Rezoning Transportation Analysis

Petition Number: 2023-038

Revision Log:

Date	Description
7-26-23	First Review (IW)
11-27-23	Second Review (DR)

SCHMATIC SITE PLAN

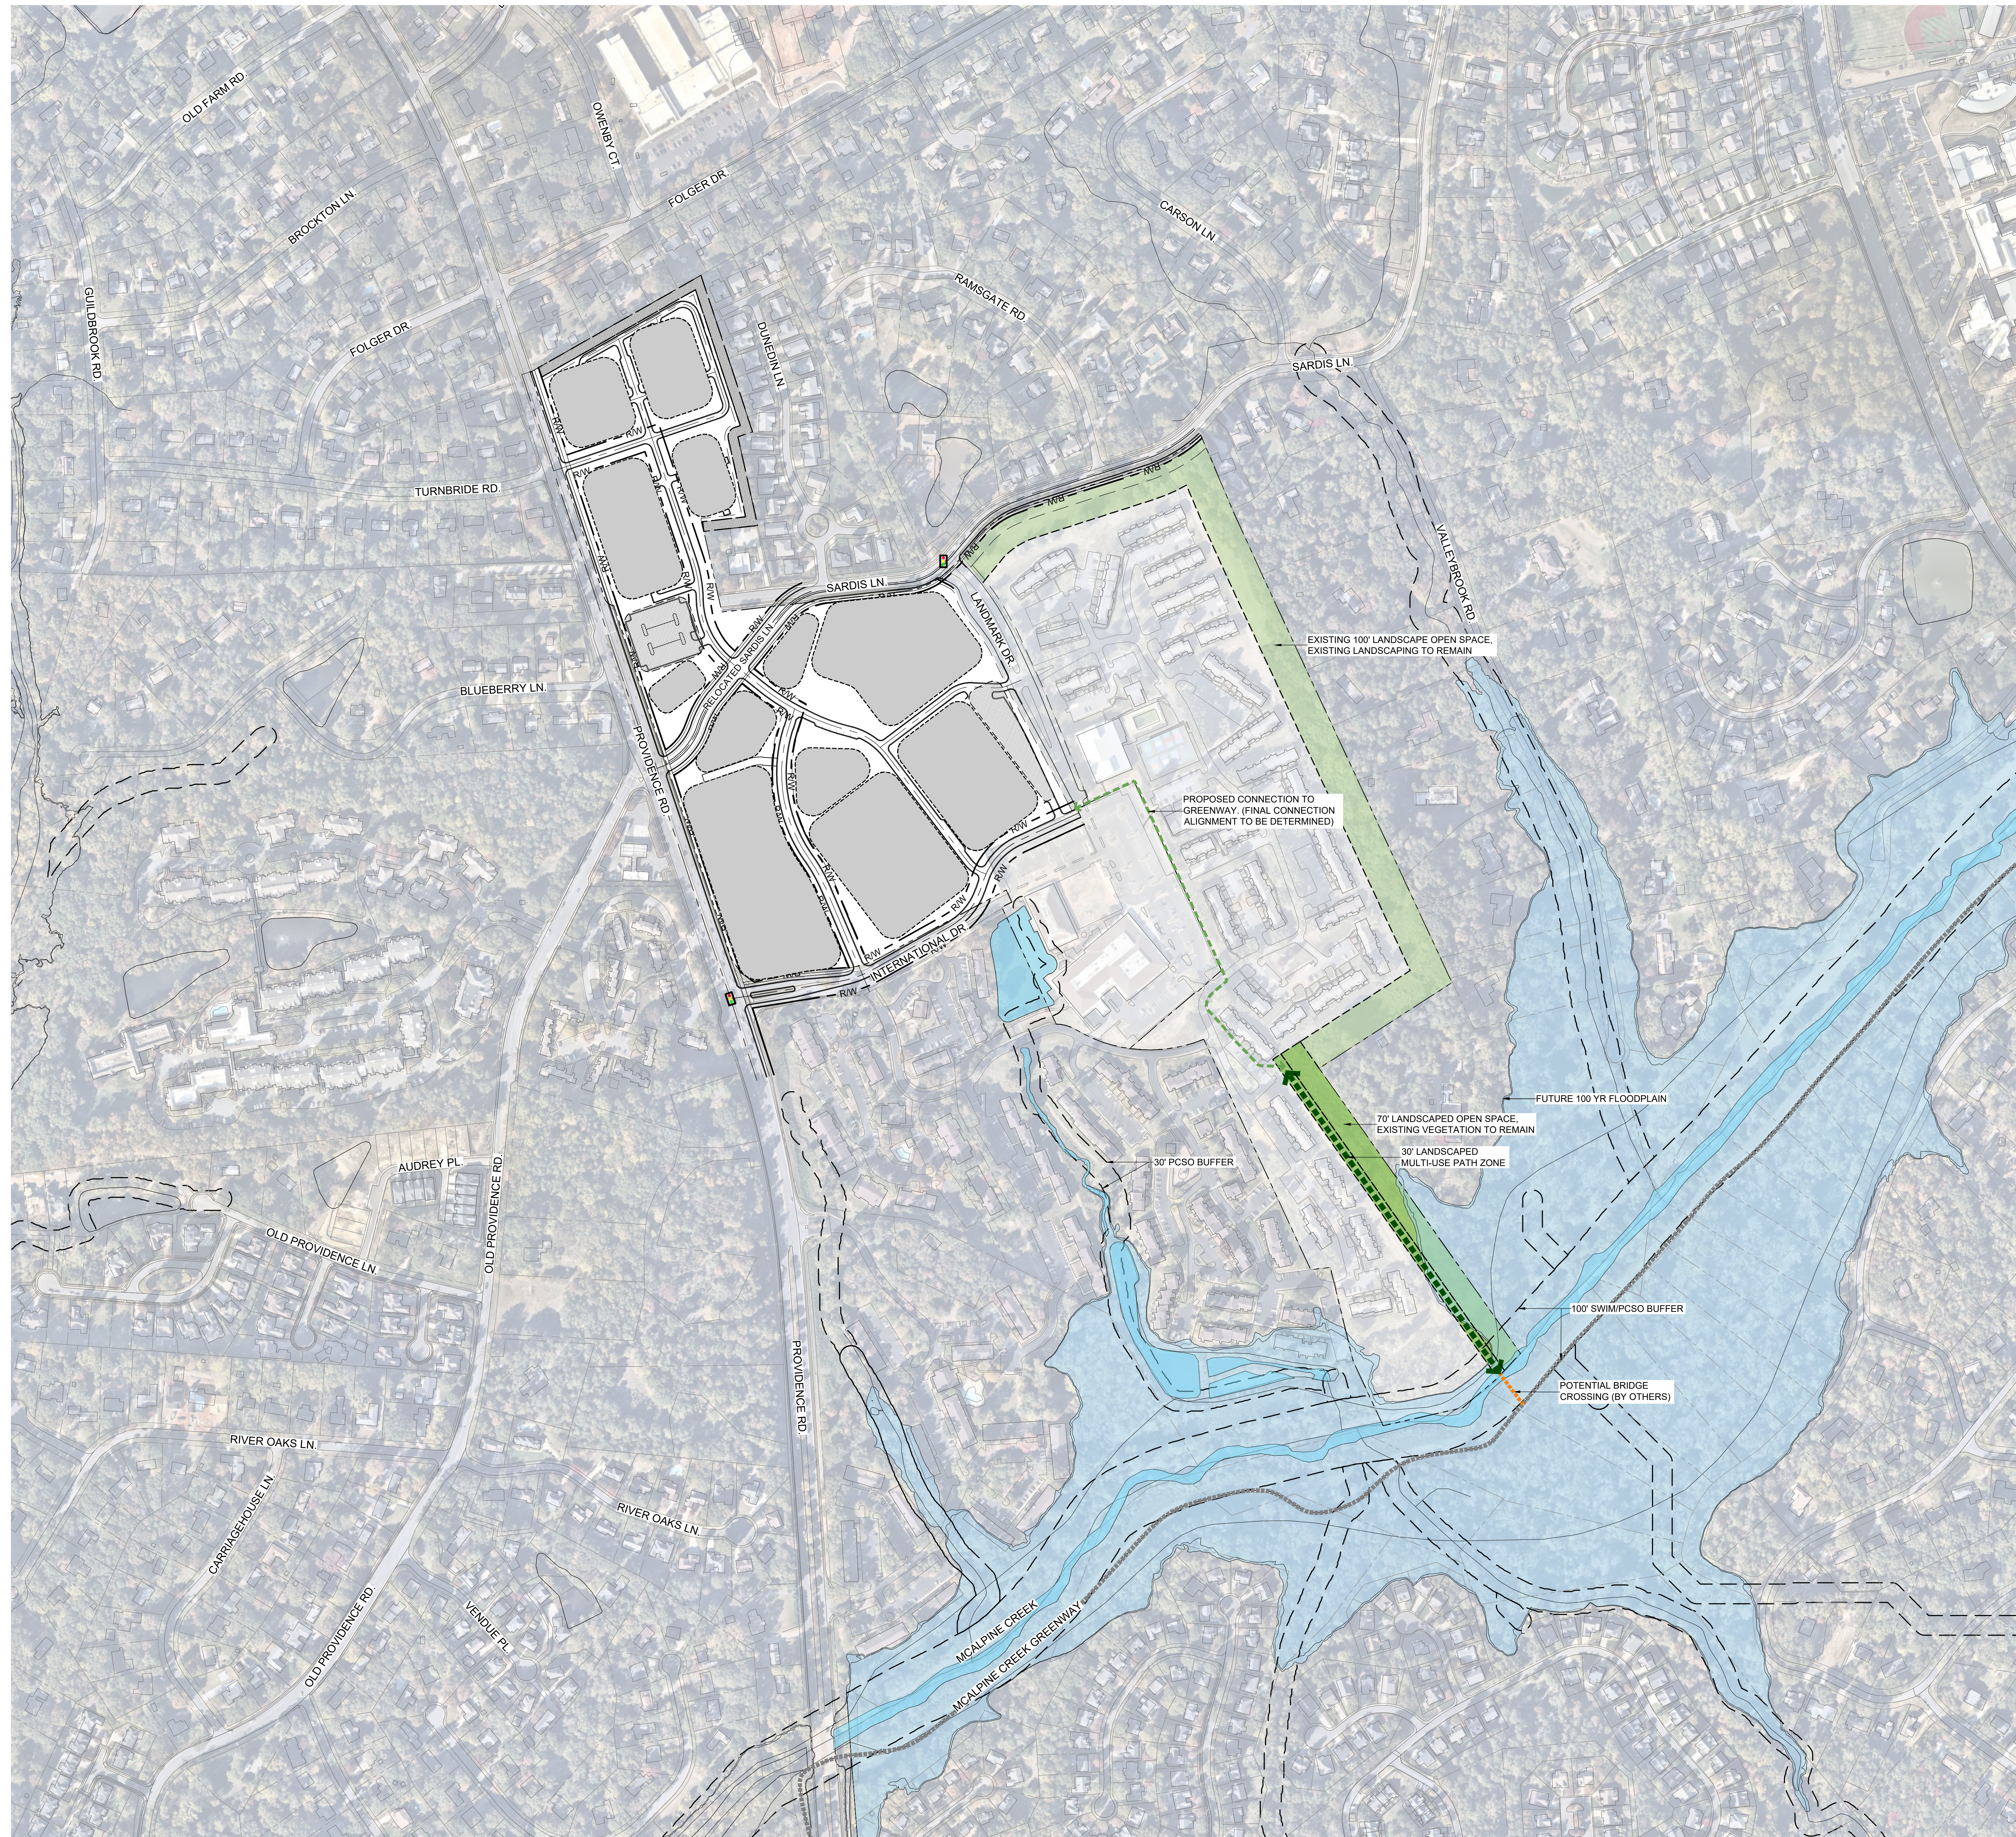
Label and dimension the curb and gutter from the centerline for each road on the site plan.

7. CDOT is requesting that the petitioner create a connection to the McAlpine Creek Greenway
